**Consultation Response from Mike Hibbert,
KC Waste Strategy(Refuse & Recycling)**

2024/92281 Land adj, 17, Whitehall Road West, Birkenshaw, BD11 2LS

Erection of 23 dwellings

Responding Ref: WPN 24-035

CLIENT:	ORION HOMES		
PROJECT:	LAND ADJACENT TO 17 WHITEHALL ROAD WEST		
TITLE:	SWEEP PATH ANALYSIS REFUSE VEHICLE ACCESS (EGRESSING)		
SCALE @ A3:	NTS	APPROVED: DRS	DATE: 27/06/2024
PROJECT No:	2024376	DRAWING No: DPL SK007	REV: A
© Development Planning Limited

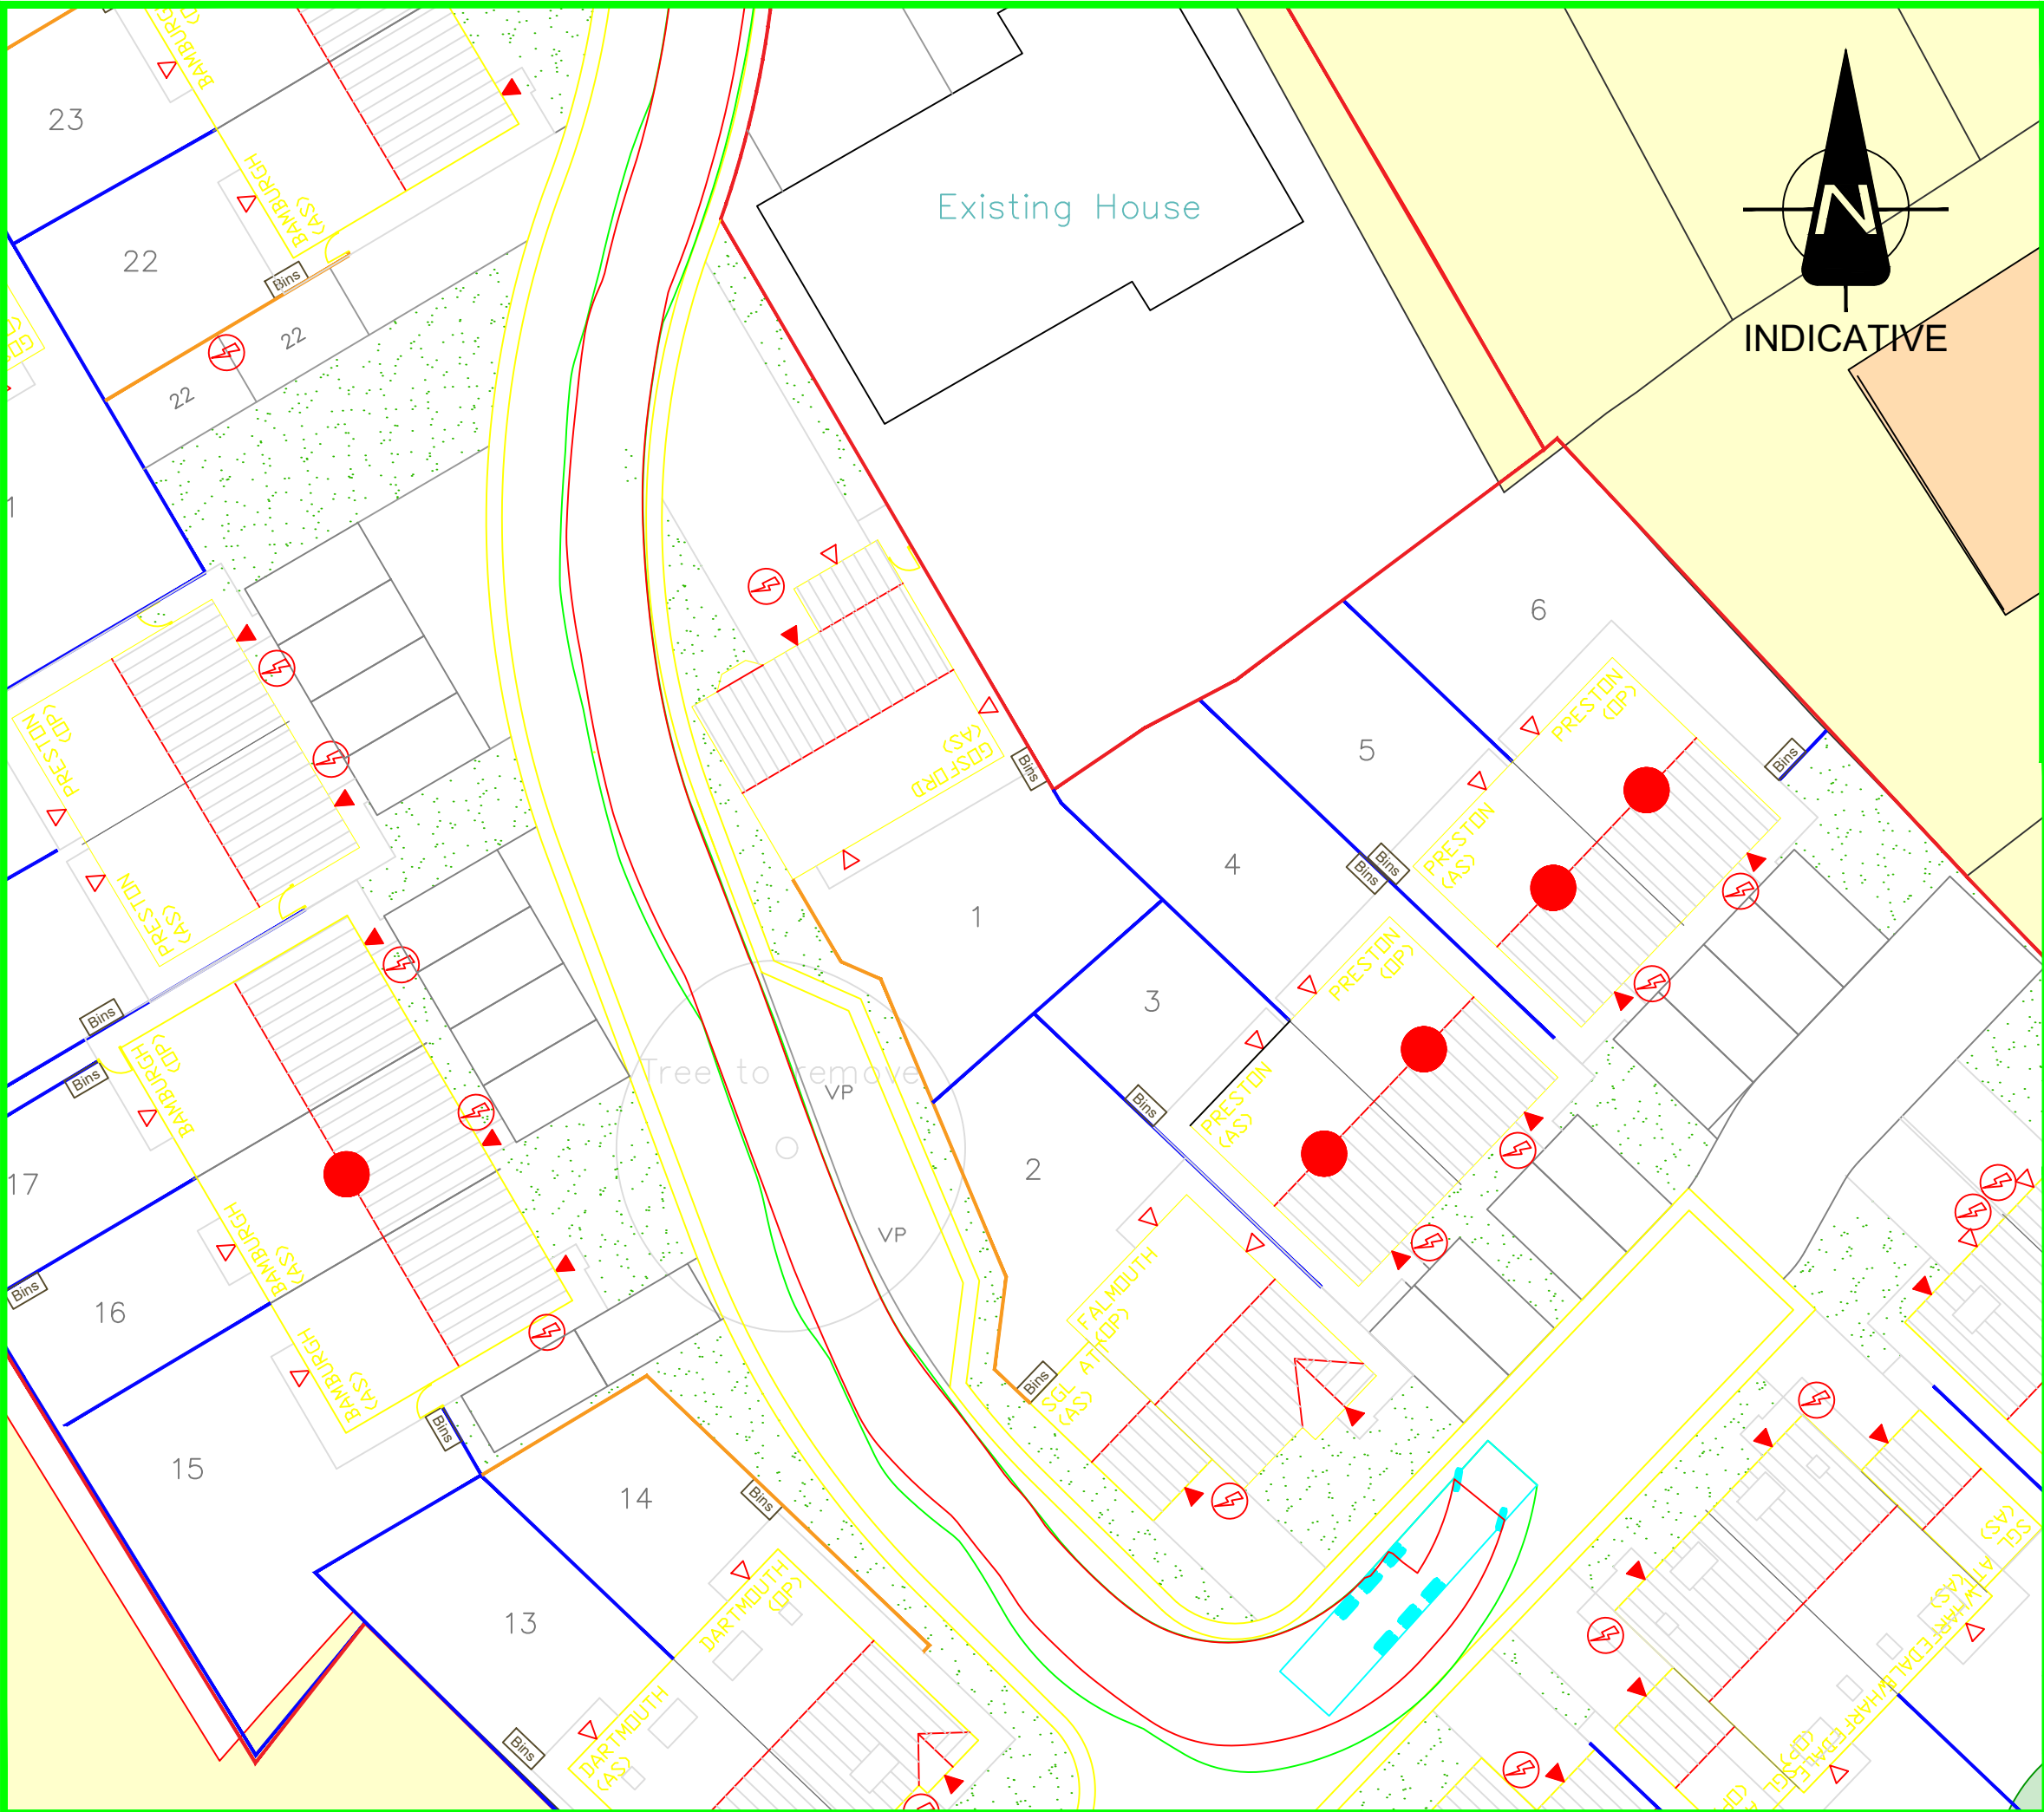
- Swept path analysis must show the manoeuvrability of this vehicle throughout the site, demonstrating the safe passing of other vehicles likely to be using the road – either parked or moving.

- Parked cars are a perpetual problem for RCV access and as such it is important to account for potential parking spaces, even where these are undefined when assessing RCV access around the site.

- The turning head between Plots 9 and 12 must be demonstrably sufficient for an 11.22m refuse collection vehicle. **Active measures should be taken to prevent parking in the turning head as otherwise an RCV would have a long reverse manoeuvre, that is a recognised safety risk and is not acceptable.**

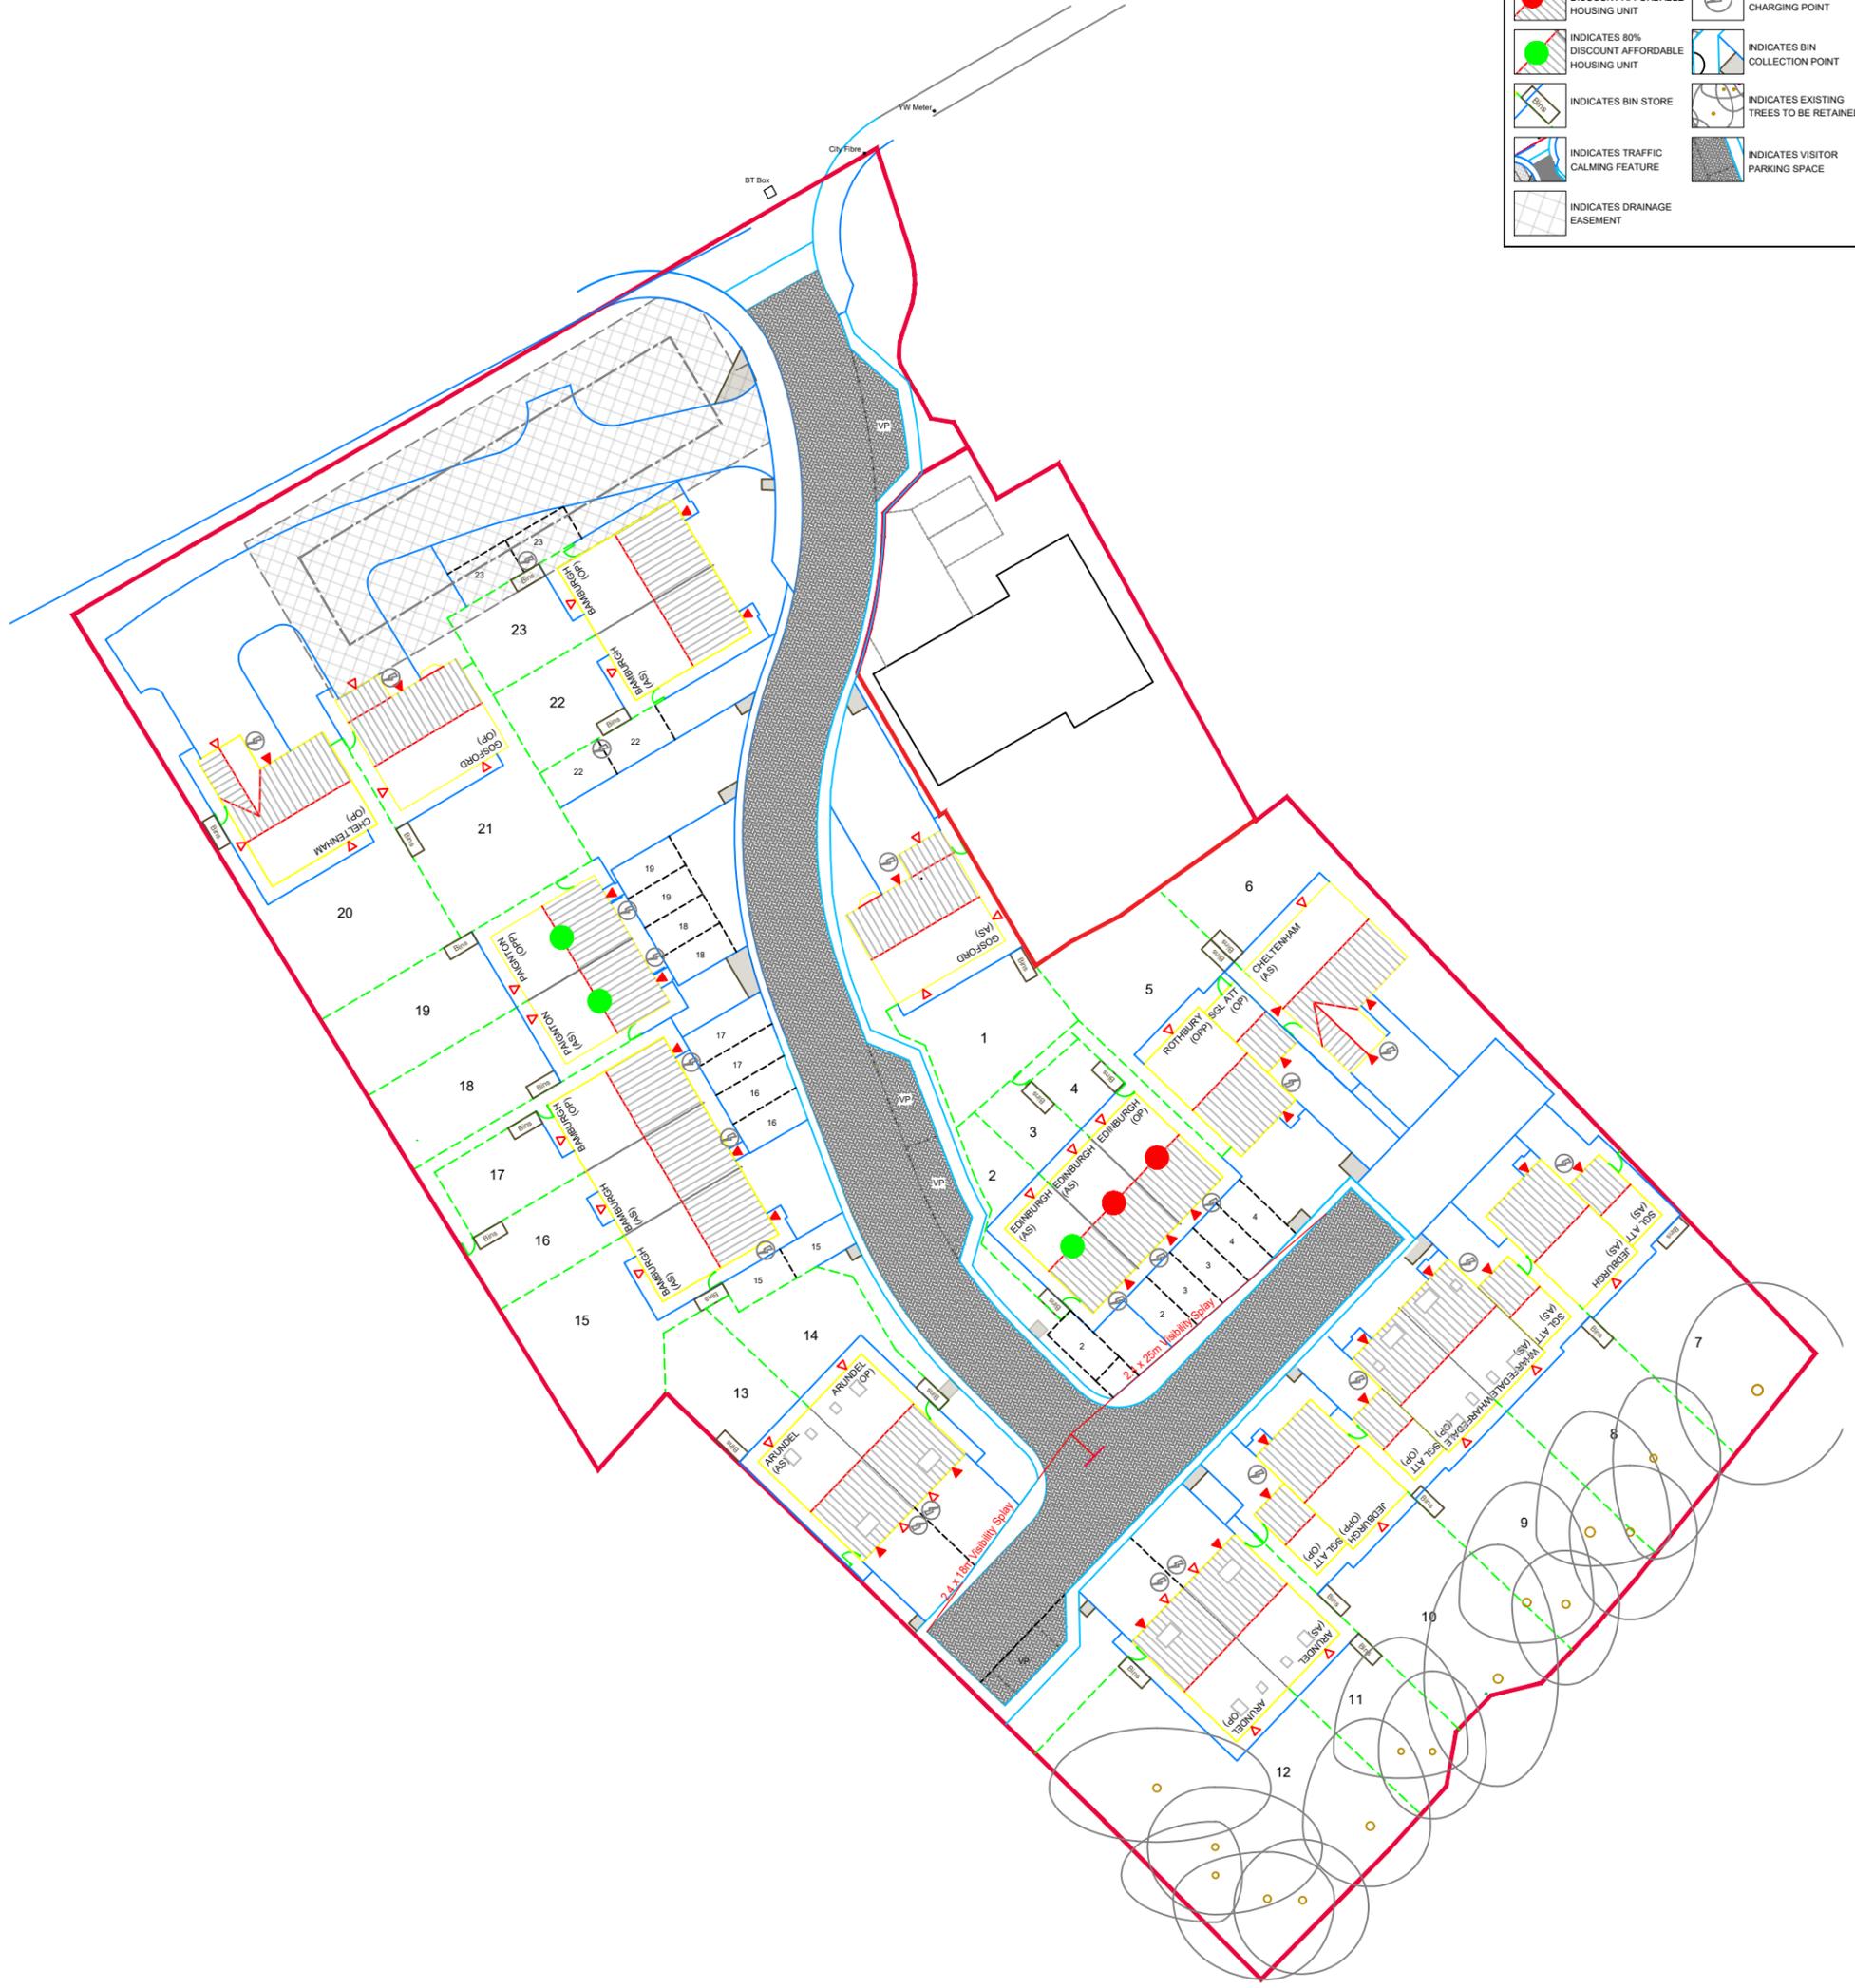
The Plan is annotated with the location of bin storage areas in the rear gardens of the properties.

- Space will be required for 3 x 240ltr bins in the rear gardens of each property. As the proposed dwellings have private gardens, opportunities to encourage composting should be sought to better meet the council's 'clean and green' objectives for waste reduction. Guidance indicates the storage footprint for a 240ltrs wheeliebin is 940mm x 780mm.

- For plots where bin storage is in the rear gardens gated access should be shown to be secure, gates wide enough to pass through and the route between the rear gardens and the front access road must not require residents to pull bins up/down gradients of more than 1:12.

- Access to the rear garden of Plot 16 is via a convoluted path around the rear of Plot 17. This arrangement can result in bins in being left in the front garden and hence impacting on the Streetscene rather than being returned to the storage space on collection day. Consideration should be given to providing direct access to the rear garden via a ginnel within the terrace of plots 15 to 17.

- There is no indication of space for the presentation of bins on collection day. It is important to ensure that bins do not cause obstruction to pedestrians or other highways users when presented for collection, particularly where space requires these to be left in clusters. Bin presentation space should be identified for each plot, on a hard surface and where a refuse collection vehicle (RCV) can be easily reached.

- The WCA will not take a Refuse Collection Vehicle onto private drives. e.g. Plots 5-8, and 20-22. The layout plan must show the location of Bin Collection Points (BCP's) for presentation of wheeliebins adjacent to the adopted highway. Guidance BS5906:2005 specifies that the maximum drag out distance from the property to the Bin Collection Point (BCP) is 25m. This is an issue for Plots 6 and 7 with a drag out of approximately 46m.
